Office of Environment & Heritage

RE: Finley Solar Project (SSD 8540) – Berrigan LGA – Exhibition of Environmental Impact Statement

ATTACHMENT A OEH Assessment Summary for the Finley Solar Project Environmental Impact Statement (SSD 8540)

Figure 1.1. Project location

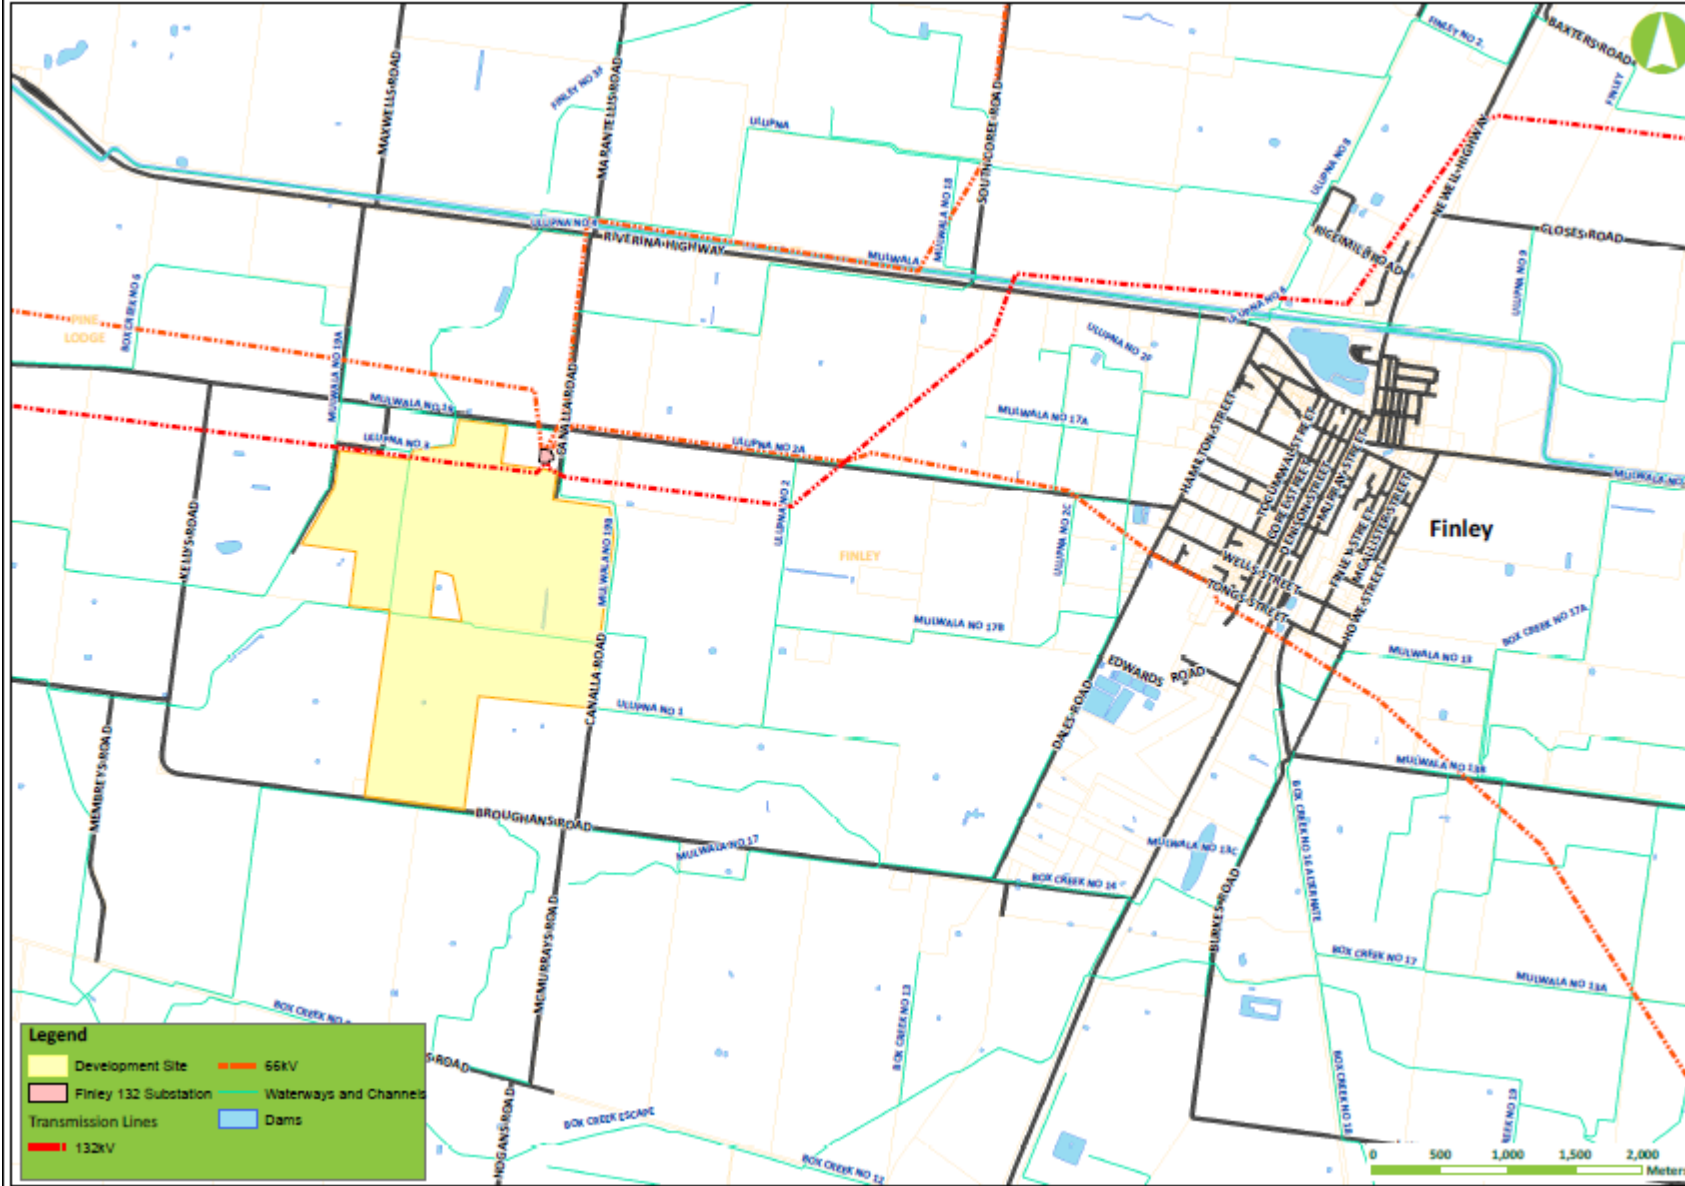
Figure 1.2 in the BAR is intended to convey information that is integral to the biodiversity impact assessment. The legend and text for Figure 1.2 is very small and therefore difficult to read, making the figure hard to interpret. The Location and Sites Map (BAR Figures 1.1 and 1.2) do not show all of the features required in the FBA (section 4.1.1.2). Some of these features are shown in Figure 3.1 with the assessment circles. Figure 1.2 should be revised so that the required information is presented clearly.
